SUNSET VILLAGE FILING NO. 4

CONSTRUCTION PLANS

EPC STORMWATER REVIEW COMMENTS
IN ORANGE BOXES WITH BLACK TEXT

PHASE 1 (JAYHAWK AVENUE)

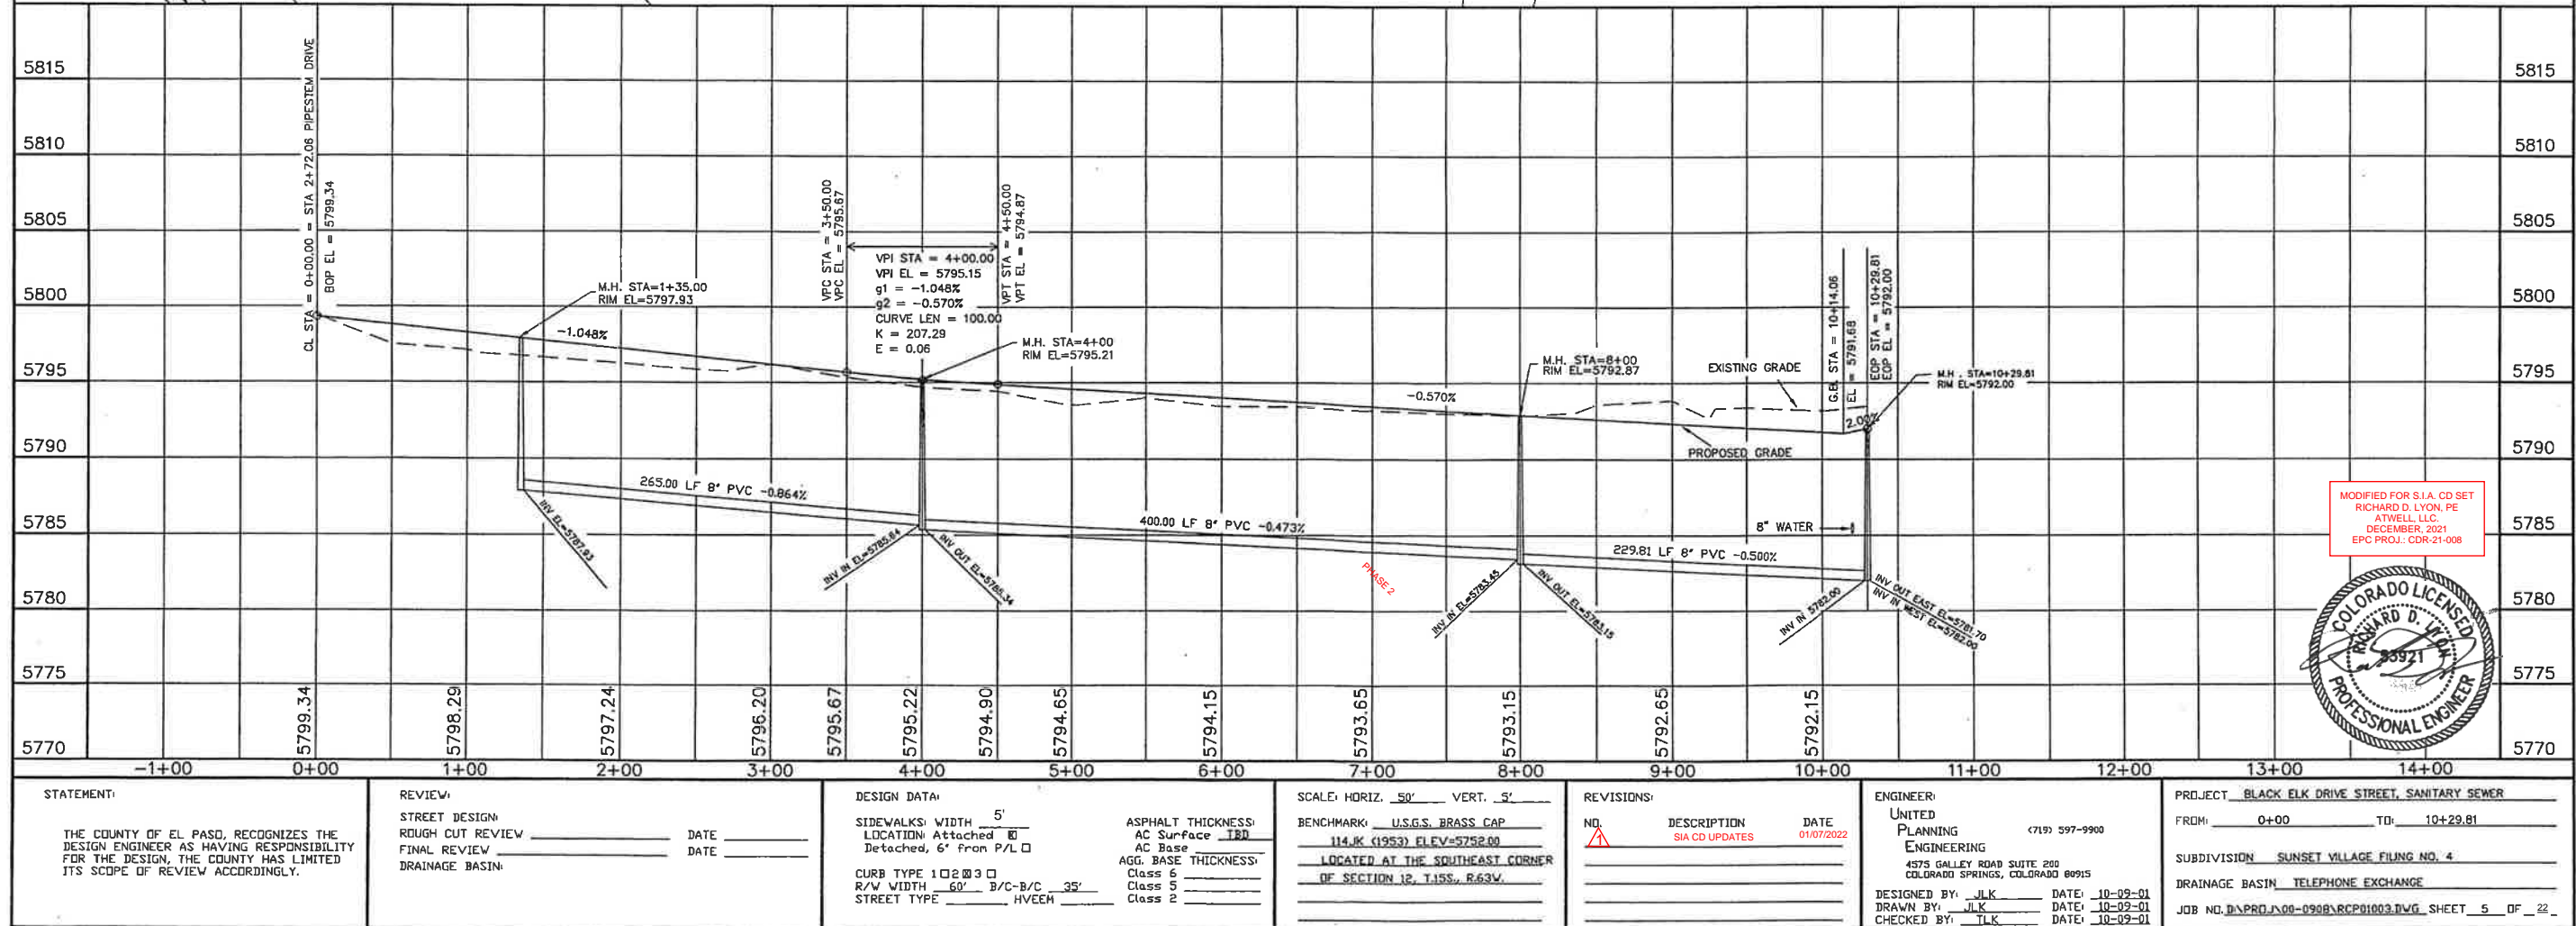
Redline comments on sheet 3 applies to these intersections.

DEVELOPED DRAINAGE & EROSION CONTROL PLAN

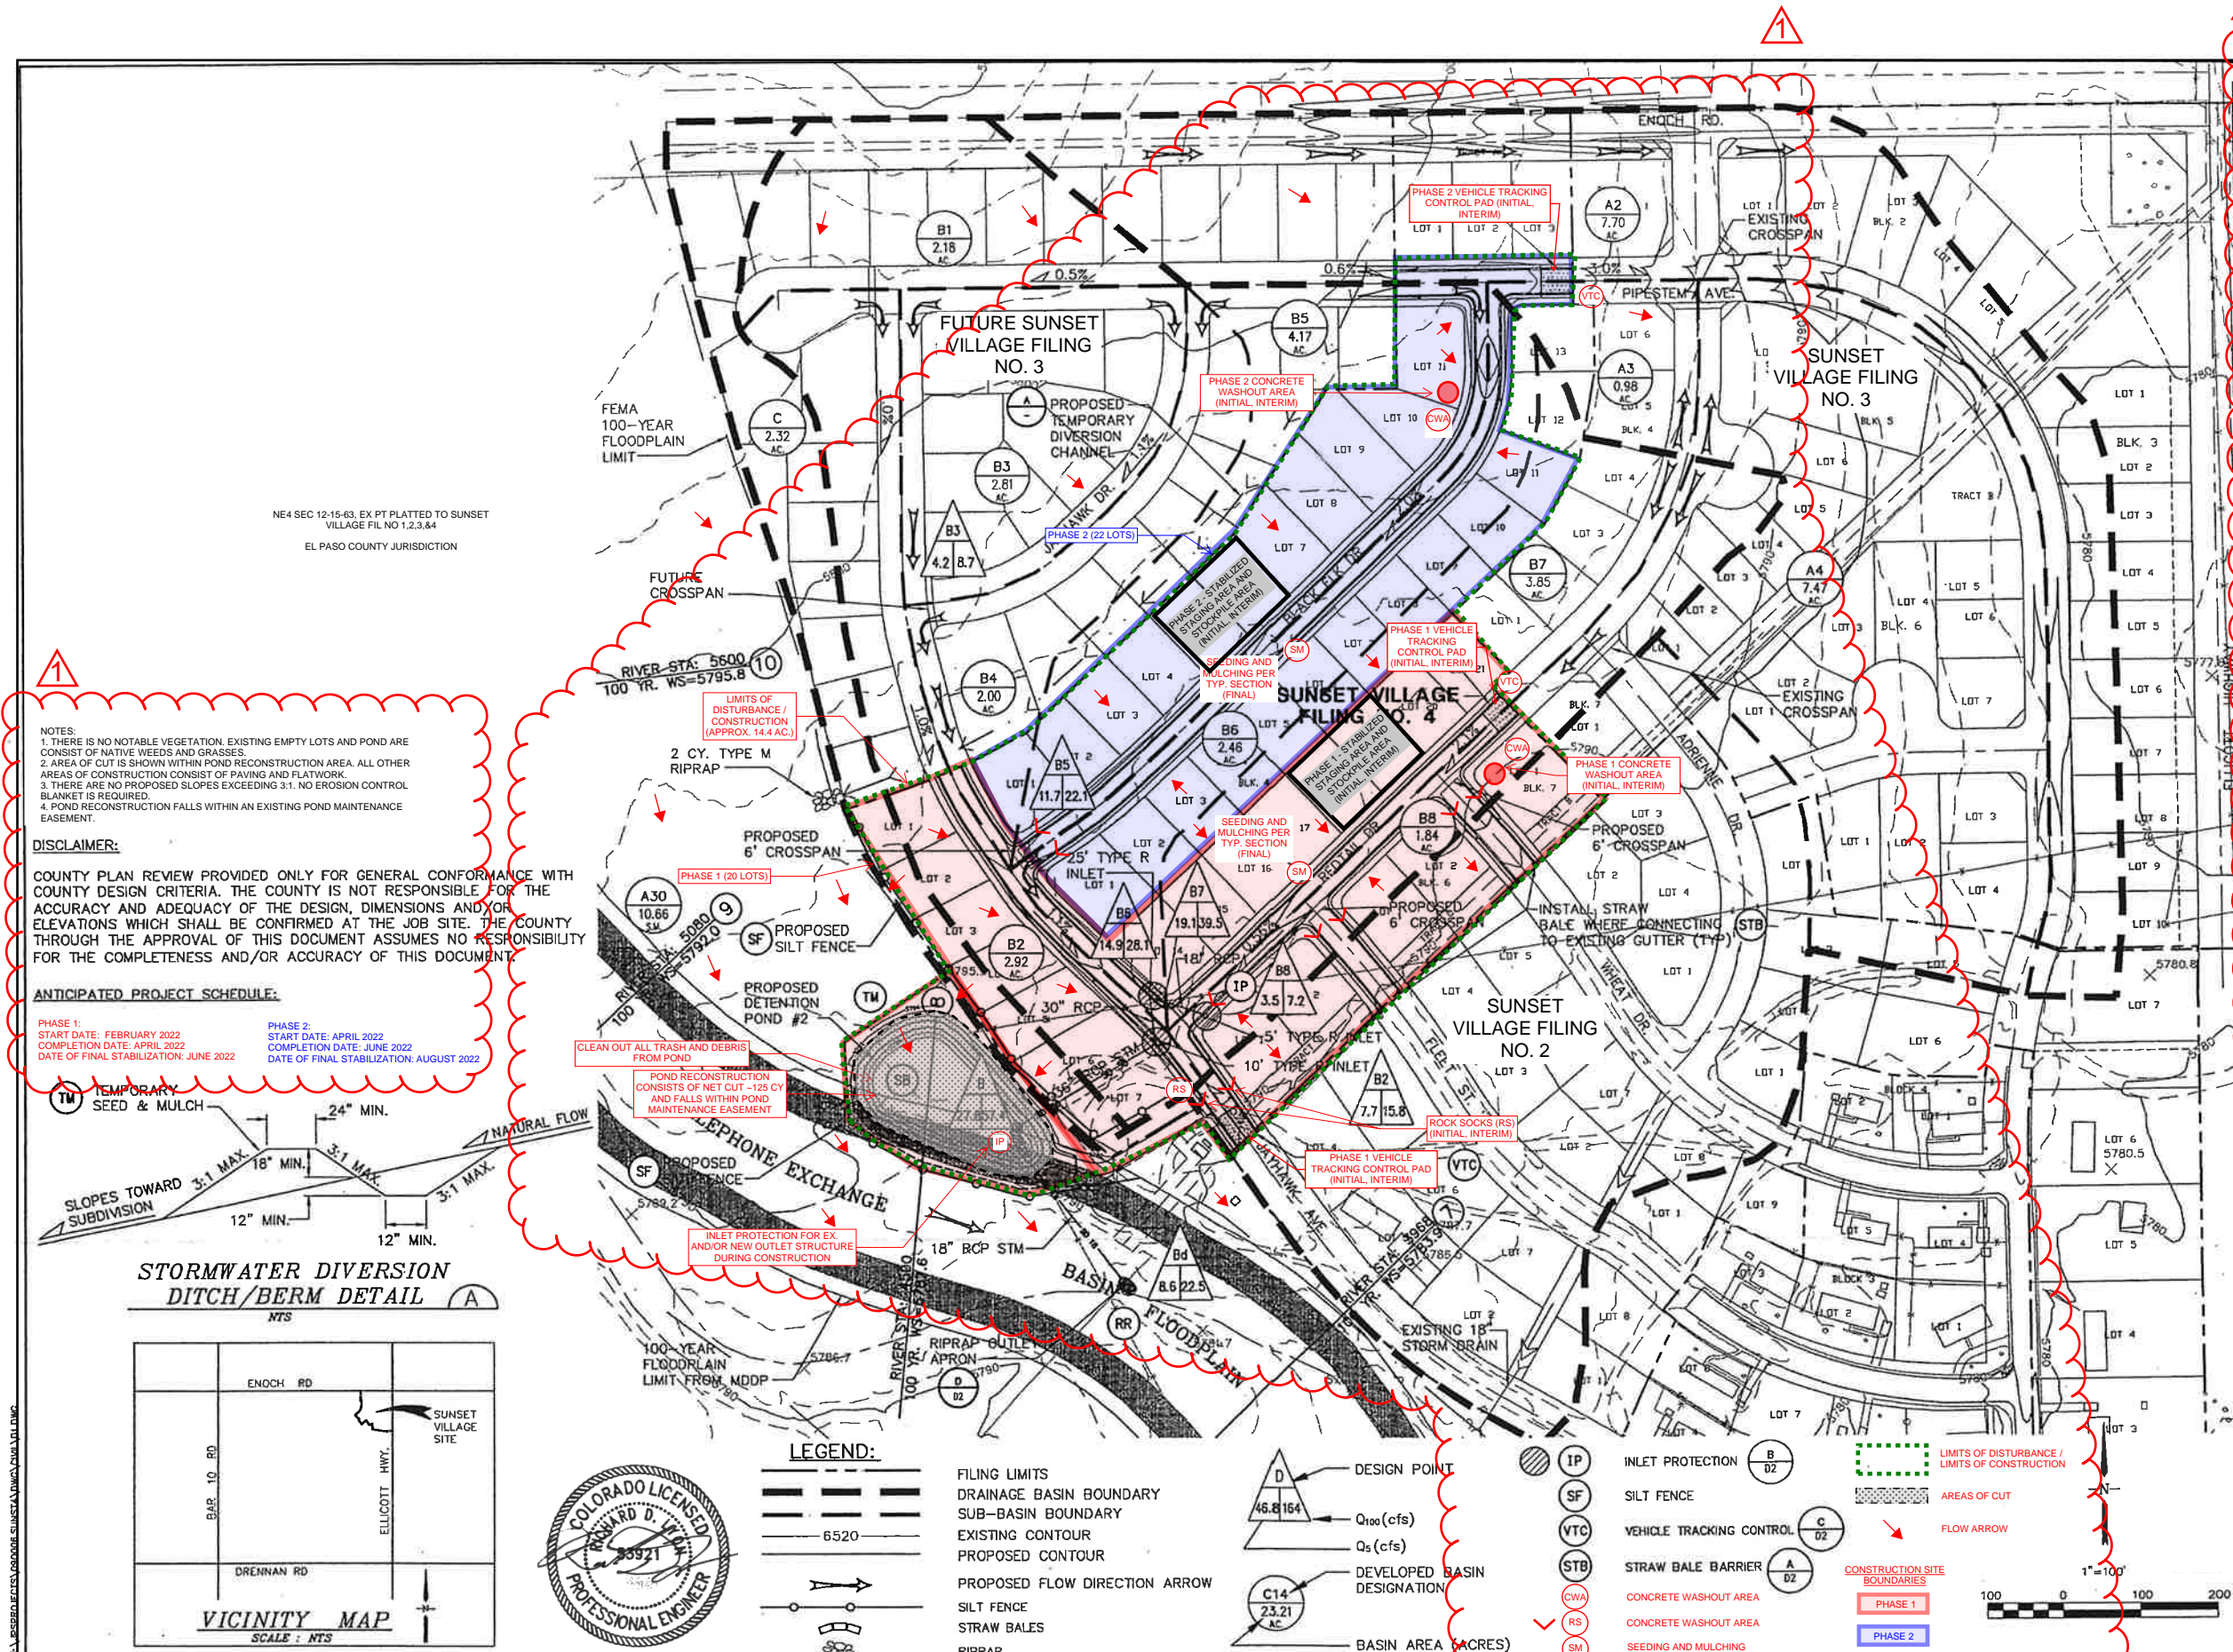
Remove VTC if not required with the remaining work for Filing 4 and update the financial assurance estimate

Place VTC(s) as needed closer to the entrance to function for all construction vehicles exiting the site.

Checklist items H and M - show both on plans and legend. If "limits of disturbance" and "construction boundary" are the same, can make one linetype for "limits of construction/disturbance" or otherwise show as separate linetypes for each on the legend and figure.

Label all proposed temporary construction BMP's by phase of implementation (initial, interim, final) - via labels in parenthesis next to each BMP in the legend and/or via a table on the plans outline which BMP's are installed at which stage.

Not advisable to place this at near the low point of the site within the flow path of runoff --- if the adjacent inlet clogs and overflows, the CWA will be washed out. See MHFD detail MM-1 for recommended placement.

STORM DRAIN PLAN & PROFILE

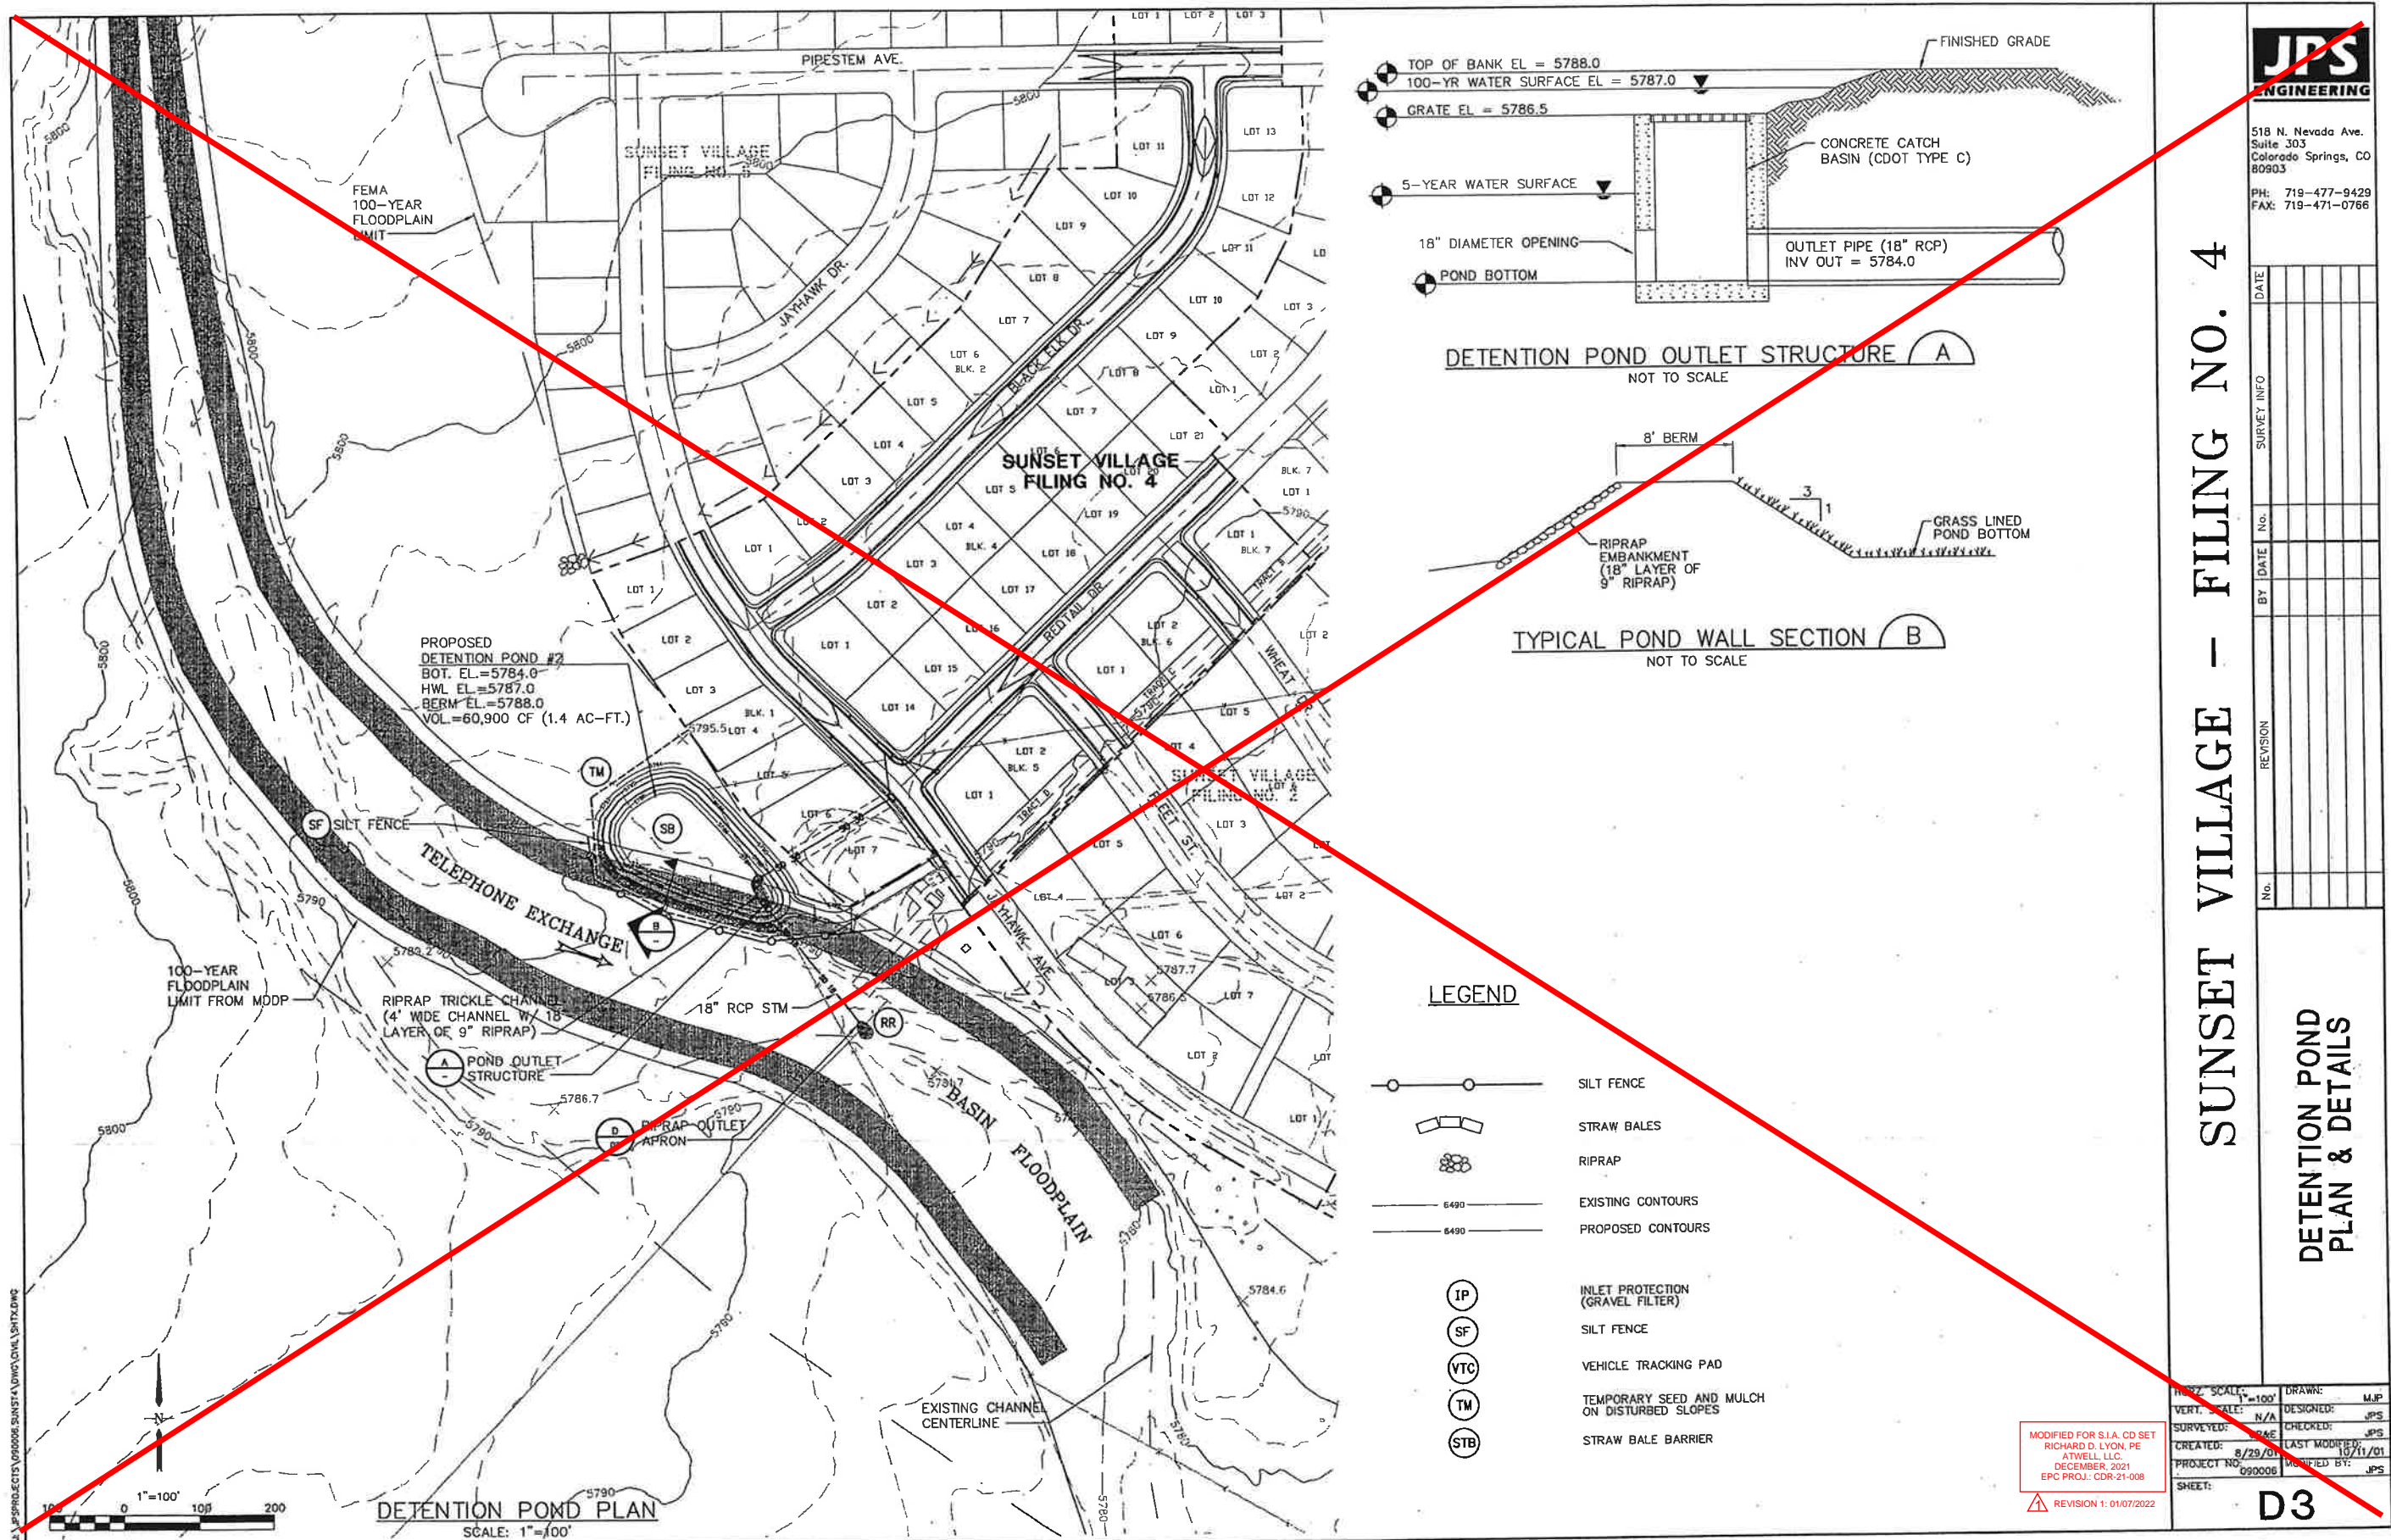
Add the notes above and modify for site specific requirements.

Do not add the notes with strike through. These are notes for the designer to consider and incorporate into the outlet structure design.

Show a pond maintenance access road from Jayhawk Ave to pond and from top of pond down to bottom of pond.

Stabilized access ramp shall be a minimum of 15ft wide and no greater than 12% slope, in accordance with DCMv1, Chap 11.2.2.

Provide roadway detail/cross section, including stone sizing and gradation.
